Our Ref: NW30034-L02-2022: BCP/bcp
Contact: Dr Brett C. Phillips

29th June 2022

ADDITIONAL INFORMATION ON FLOODING
200 ALDINGTON INDUSTRIAL ESTATE (SSD-10479), KEMPS CREEK, NSW

FIGURE 21

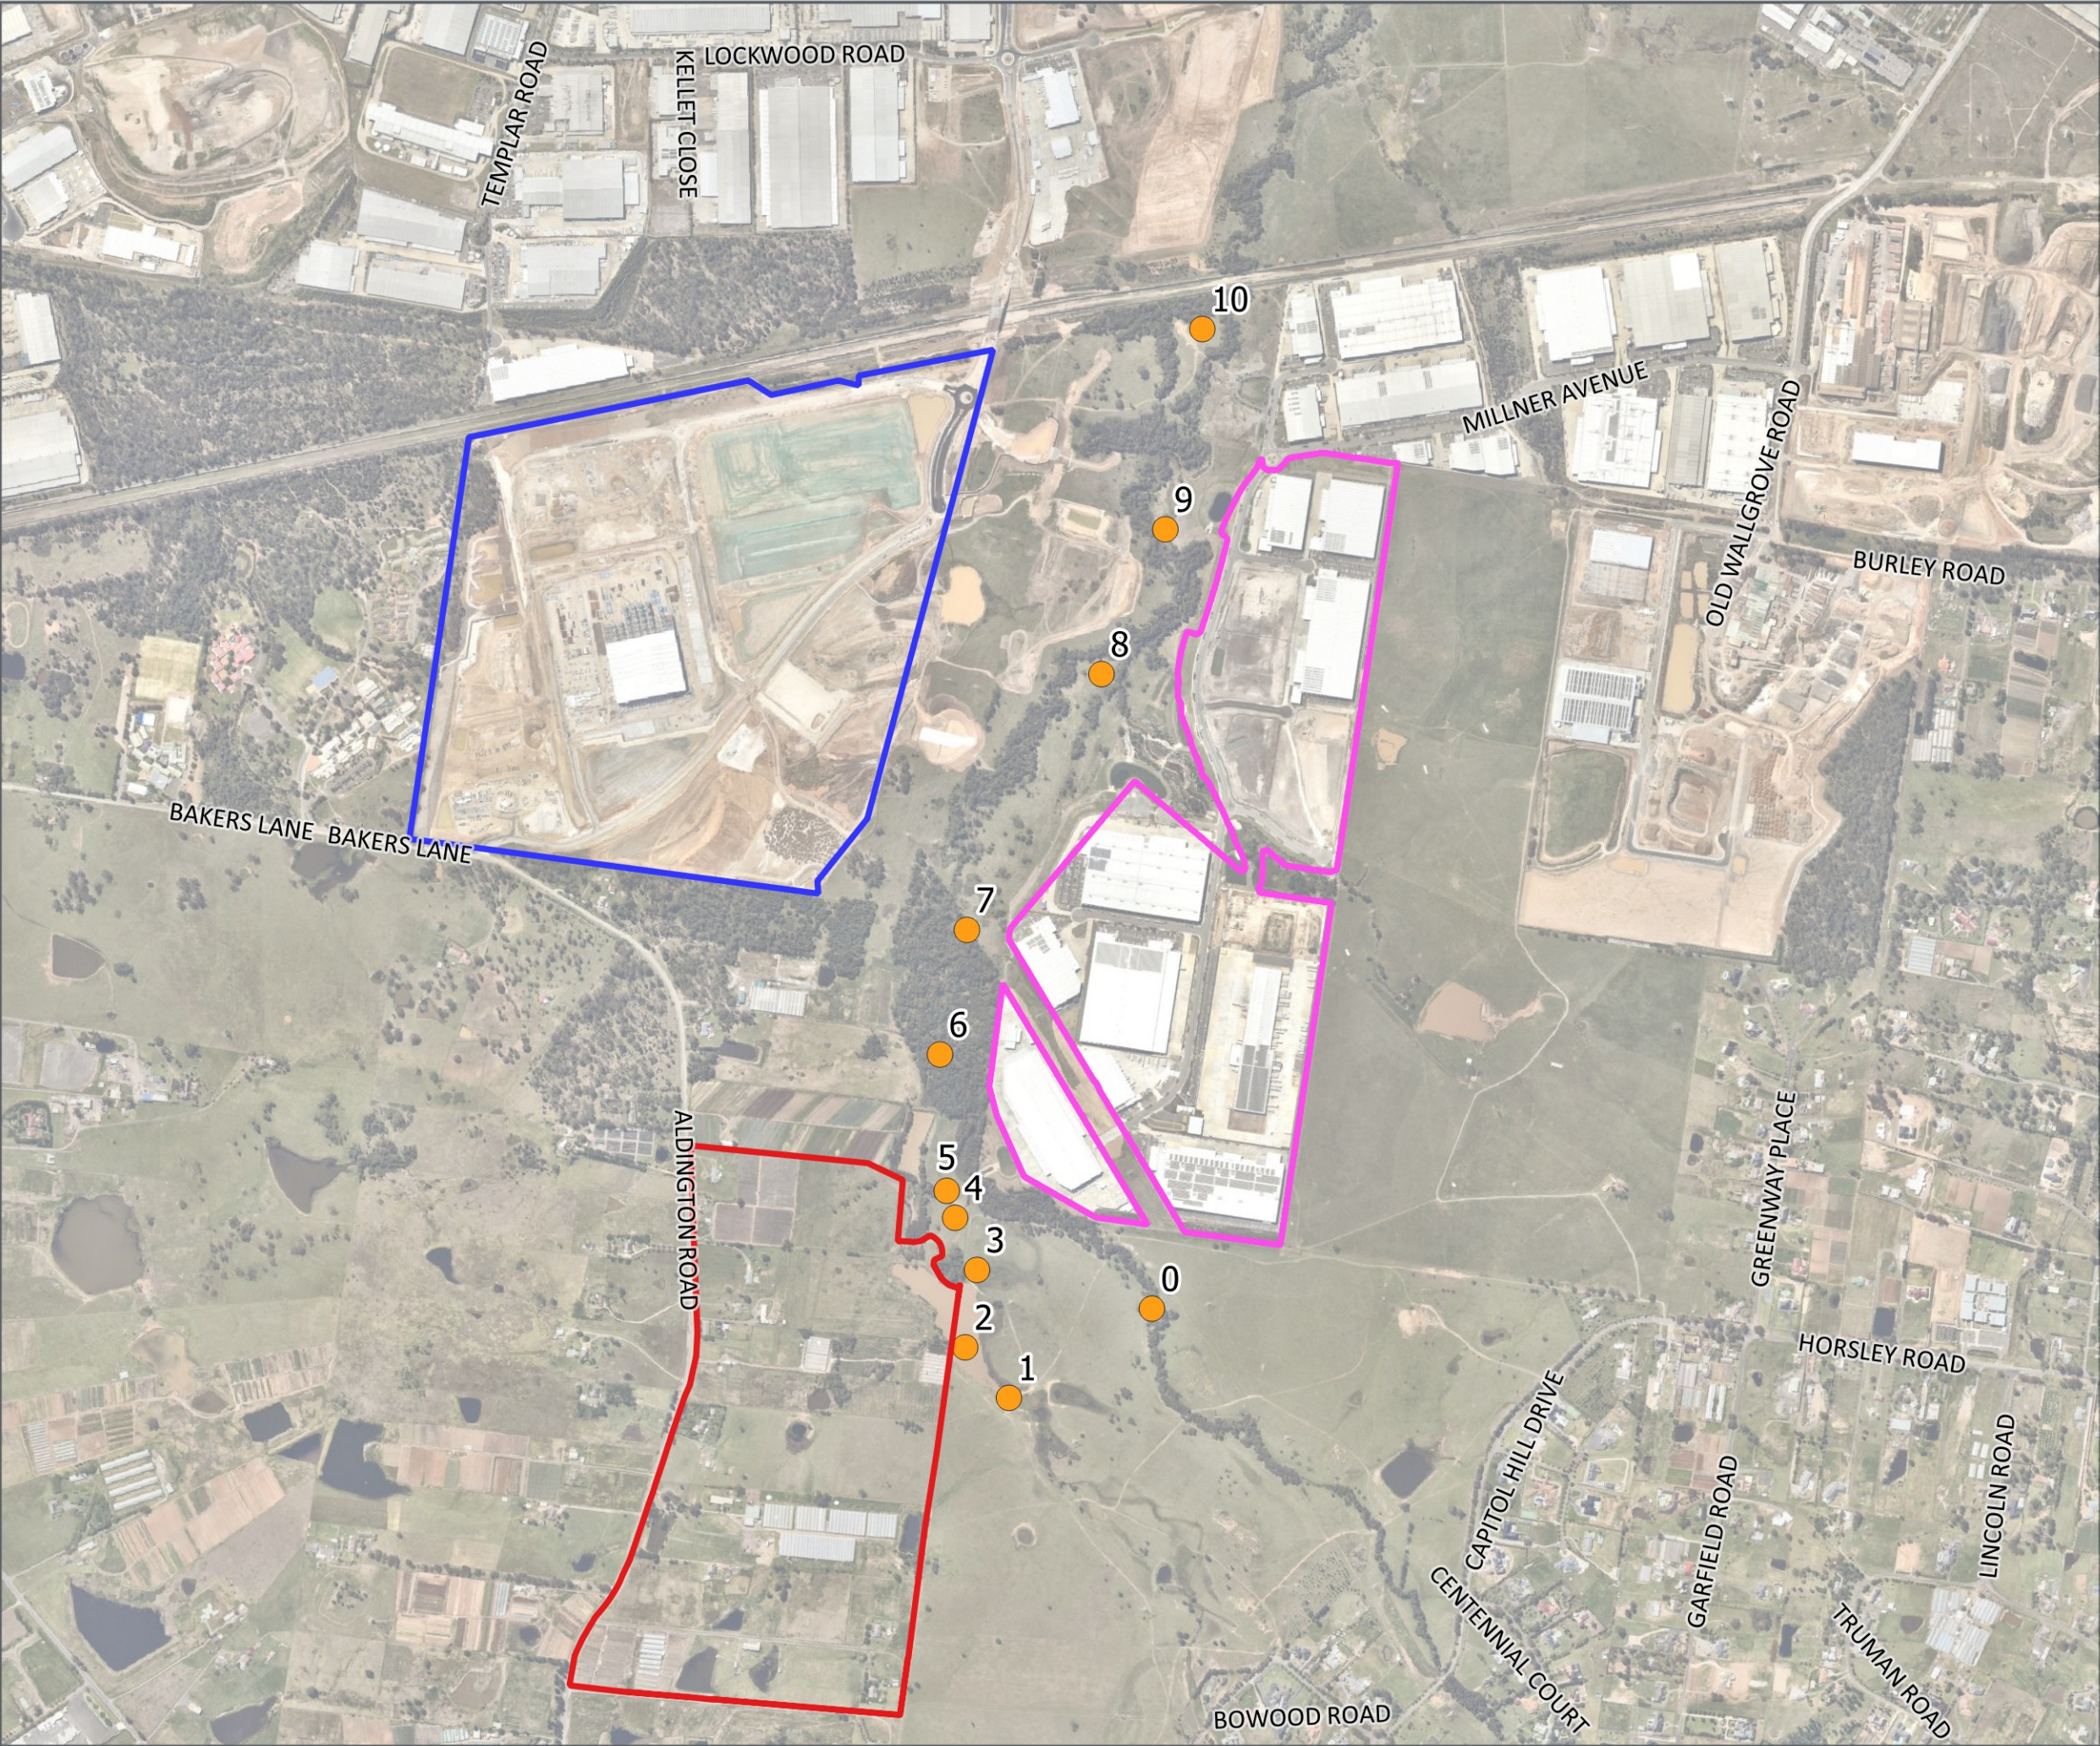
Table 1 summarises the 100 yr ARI flood levels extracted at 11 reference locations (0, 1, 2, 3, ... 10) identified in **Figure 1** for several different cases.

It is noted that between Reference Locations 1 to 5 the Case 2 100 yr ARI flood levels are 0.2 m – 0.37 m higher than the 2015 Worley Parsons 100 yr ARI flood levels.

Given that between Reference Locations 1 to 5:

- (i) the adopted benchmark 100 yr ARI flood levels are 0.2 m – 0.37 m higher than the 2015 Worley Parsons 100 yr ARI flood levels;
- (ii) the PMF levels are 0.34 m – 0.9 m higher than the 100 yr ARI flood levels;
- (iii) estimated from Figure 3 that the impact of climate change impact of climate change on 100 yr ARI flood levels in the vicinity of the subject property is broadly 0.15 m; and
- (iv) the fill platforms typically have 4+ m freeboard to the PMF level;

then it is concluded that any impact of climate change or floodplain revegetation on mainstream flood levels will not have any impact on the development.
